Application by East Anglia ONE North Limited for an Order Granting Development Consent for the East Anglia ONE North Offshore Wind Farm and by East Anglia TWO Limited for an Order Granting Development Consent for the East Anglia TWO Offshore Wind Farm

Requests for further information and written comments

Questions under EPR Rule 17 (R17QF)

Issued on 18 June 2021

Rev	Date	By	Comment	Approved:	FM				Figure	2

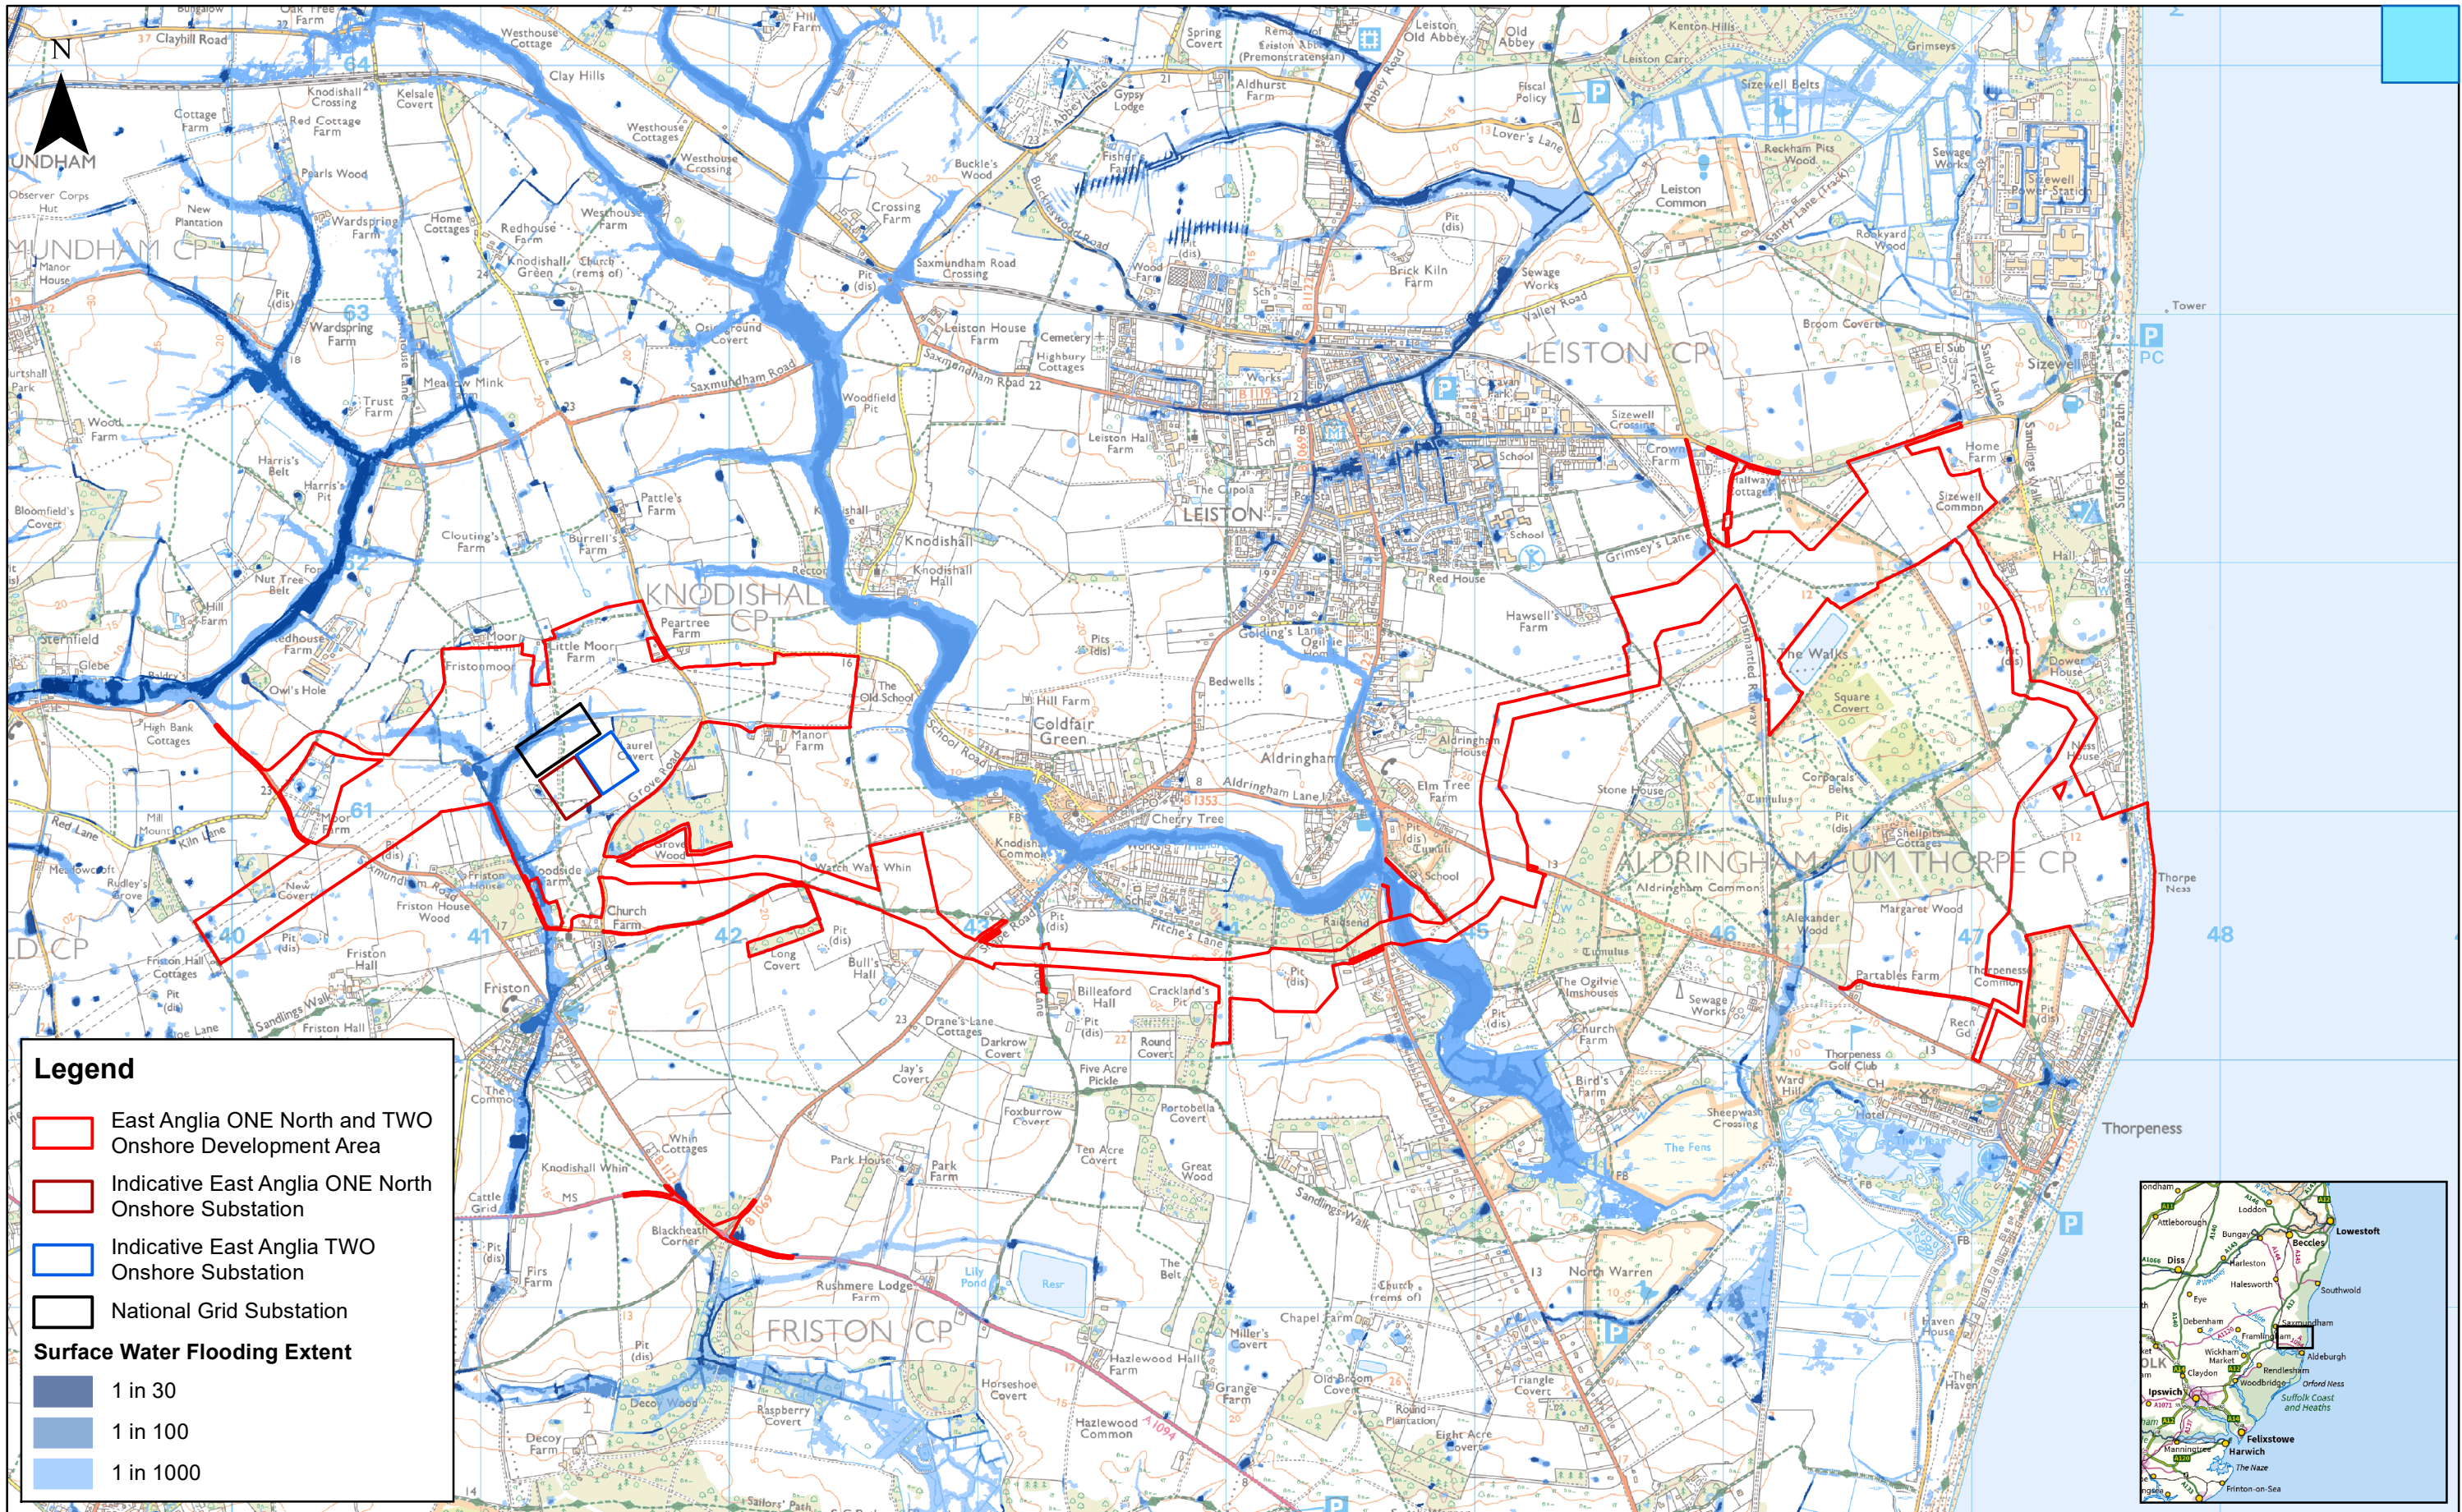
Onshore Substation Siting and Design				
R17QF.5	SCC	1	2	<p>Land Plans and Appendix 2 of the Outline Operational Drainage Management Plan (OODMP)</p> <p>Appendix 2 of the updated OODMP [AS-125] shows the order limits in relation to the SuDs basin alternative outfall on Church Lane. Are you content that the order limits shown in Appendix 2 correspond with those shown on Sheet 7 of the Land Plans?</p>
R17QF.6	SCC, Environment Agency	1	2	<p>Maintenance of the Friston Watercourse</p> <p>Paragraph 140 of the OODMP [AS-125] states that additional inspection or maintenance works required on the Friston watercourse due to the projects will be addressed by way of an agreement with the Environment Agency prior to commencement of Work Nos 30 and 41.</p> <p>To SCC:</p> <ul style="list-style-type: none"> Does this satisfy your concerns in relation to this matter and is there sufficient detail within the OODMP?
